CITY OF ALBUQUERQUE

September 26, 2018

RE: **Tr X-1, Airport Park**
2500 Yale Blvd SE
Grading Plan Stamp Date: 09/17/18
Hydrology File: M16D011D

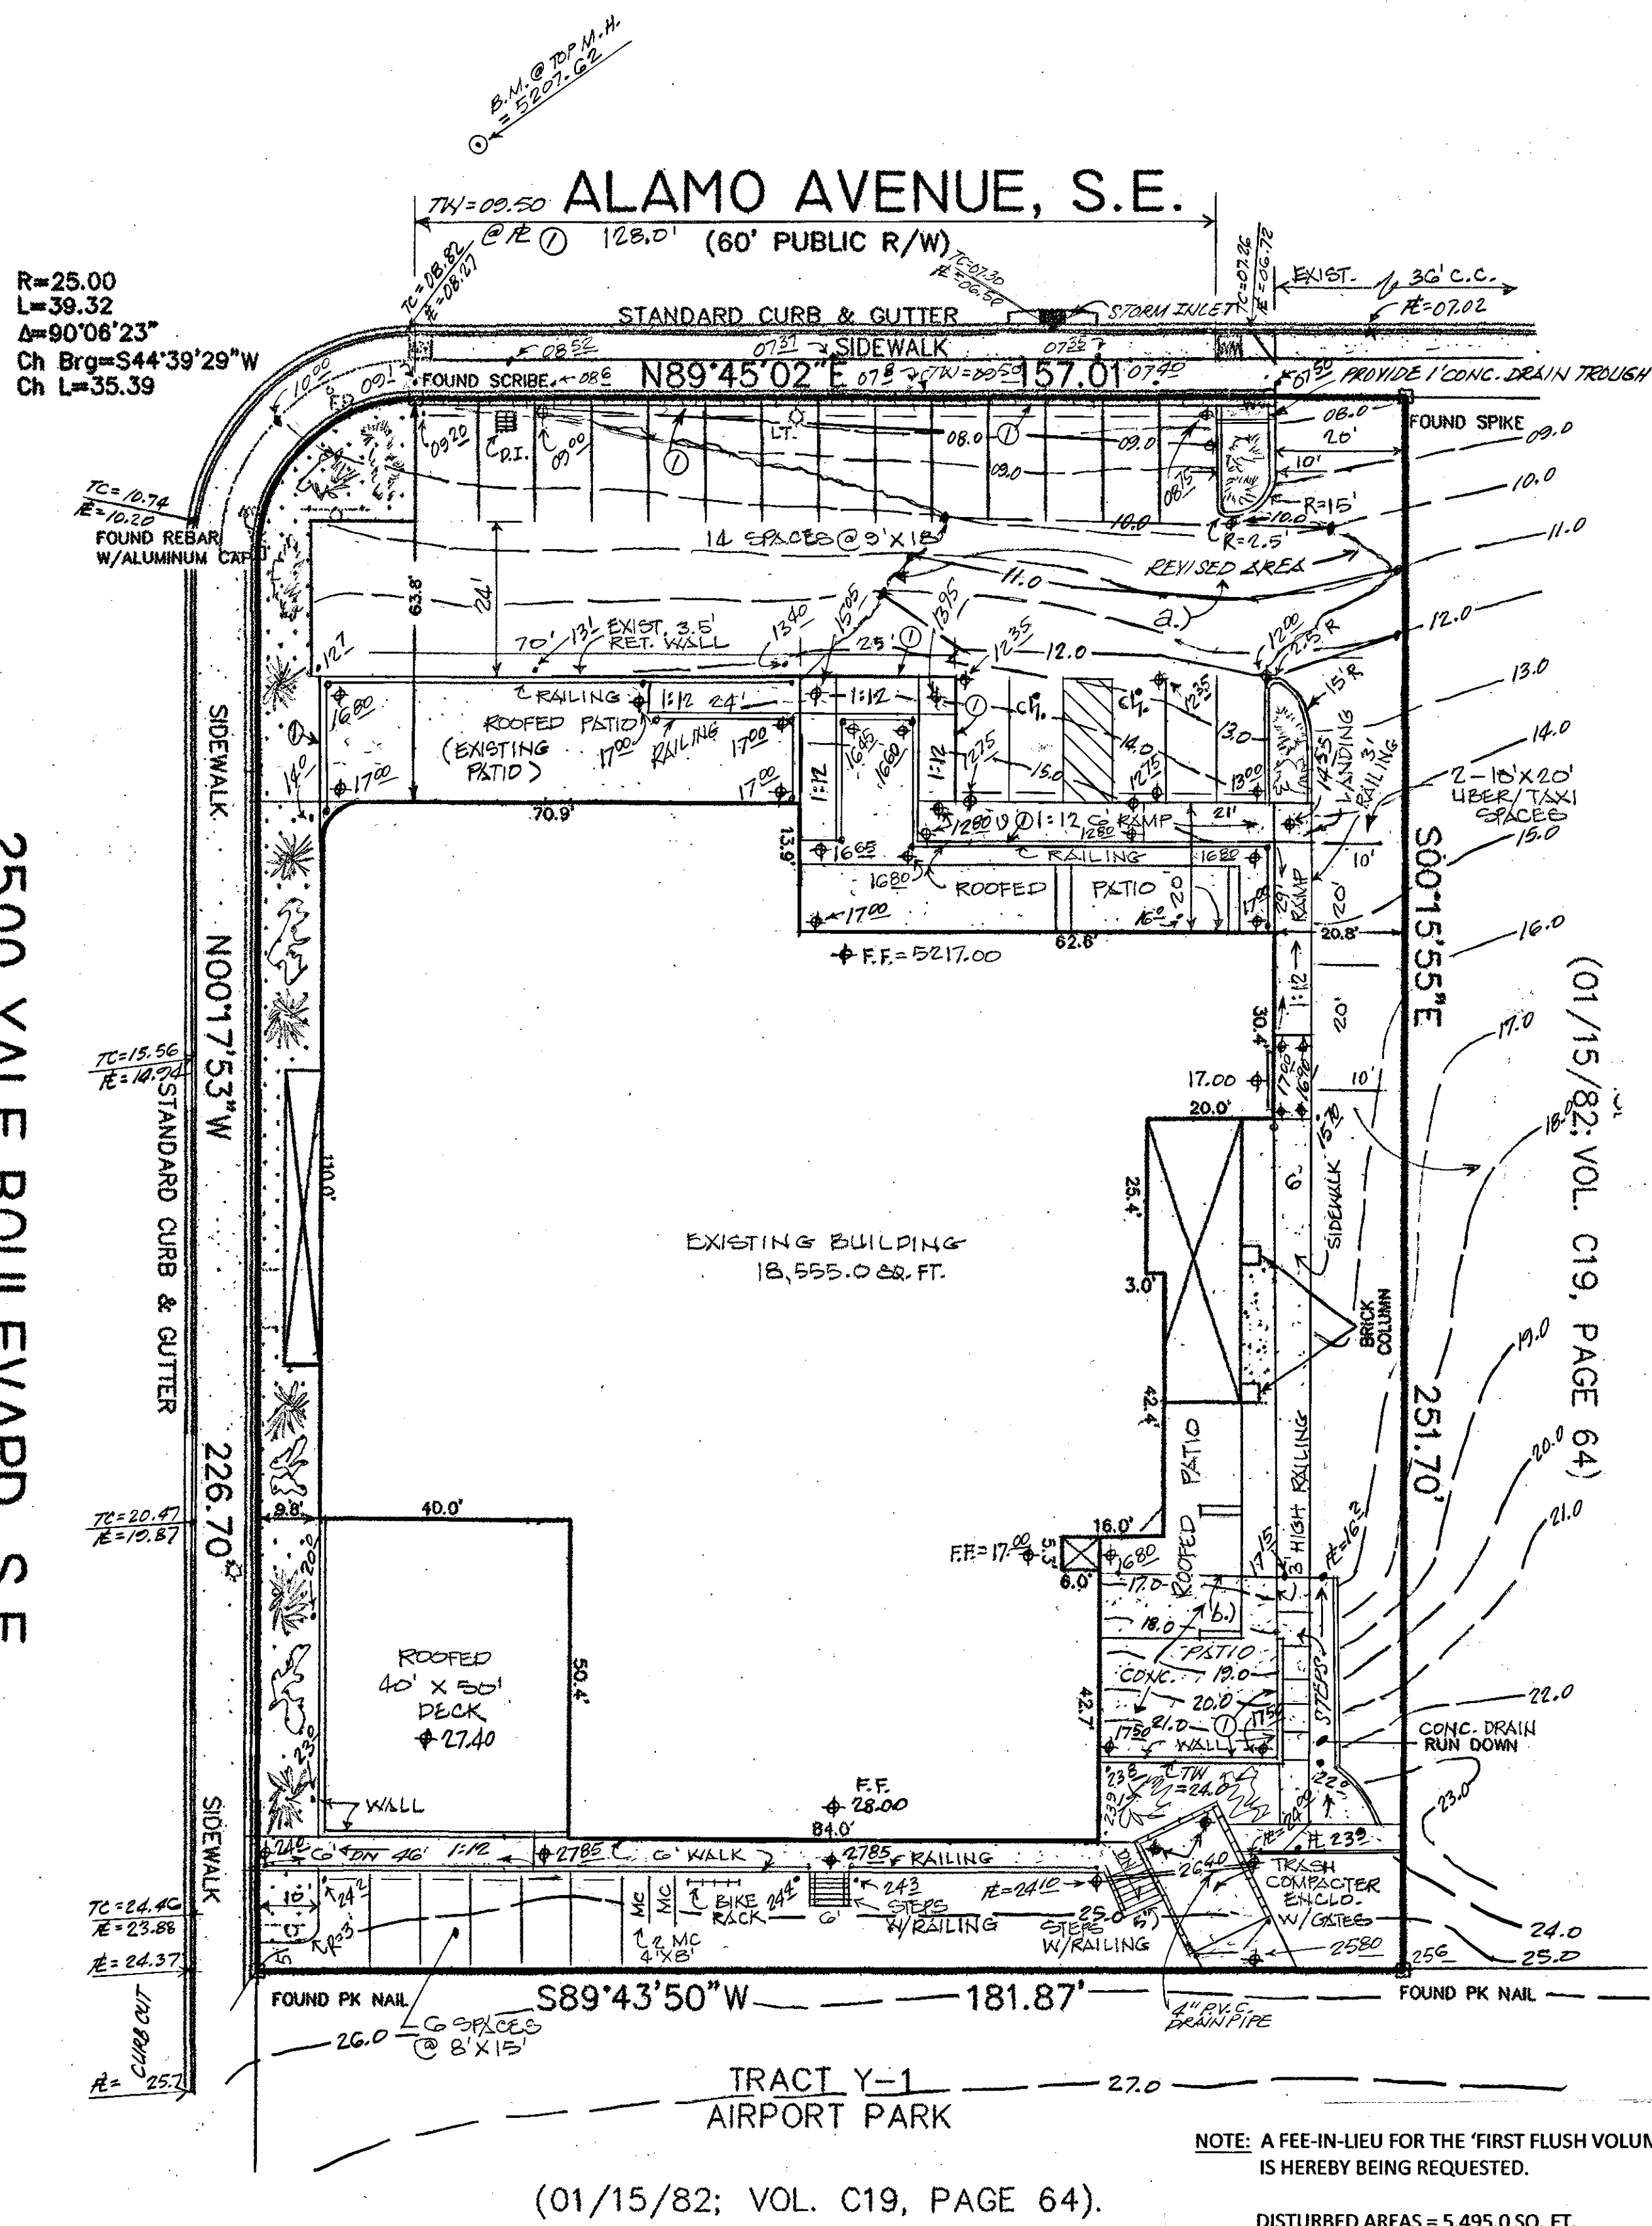
2. Include elevation datum for the benchmark.
3. Only one paper copy (and the electronic copy) is required for Hydrology submittals.
4. Add note on the plan that "No work shall be performed in the public ROW without an approved Work Order or Excavation Permit."

5. Why is the top of the retaining wall along Alamo labeled as 10.50', but the adjacent proposed parking lot grade is only 8.75'?
6. The areas of repaving and new buildings must be clearly defined on the plan and included in first flush calculations and determination of Fee-in-Lieu. This redeveloped impervious area is then used to determine the first flush retention volume at a rate of 0.26" x impervious area.

- a. If requesting Fee-in-Lieu for the first flush volume, please state on the plan so a deposit slip can be generated for the first flush volume at a rate of \$8/CF.

- b. Otherwise provide a suitably located and sized pond to capture this volume from impervious areas.
7. For Information. The new Drainage Ordinance was passed by City Council on 9/17/18 and is pending mayor signature and enactment. This may affect the timing and approval of this project. If seeking approval under the current ordinance, Fee-in-Lieu may be accepted. If seeking approval under the new ordinance, Fee-in Lieu cannot be accepted and on-site
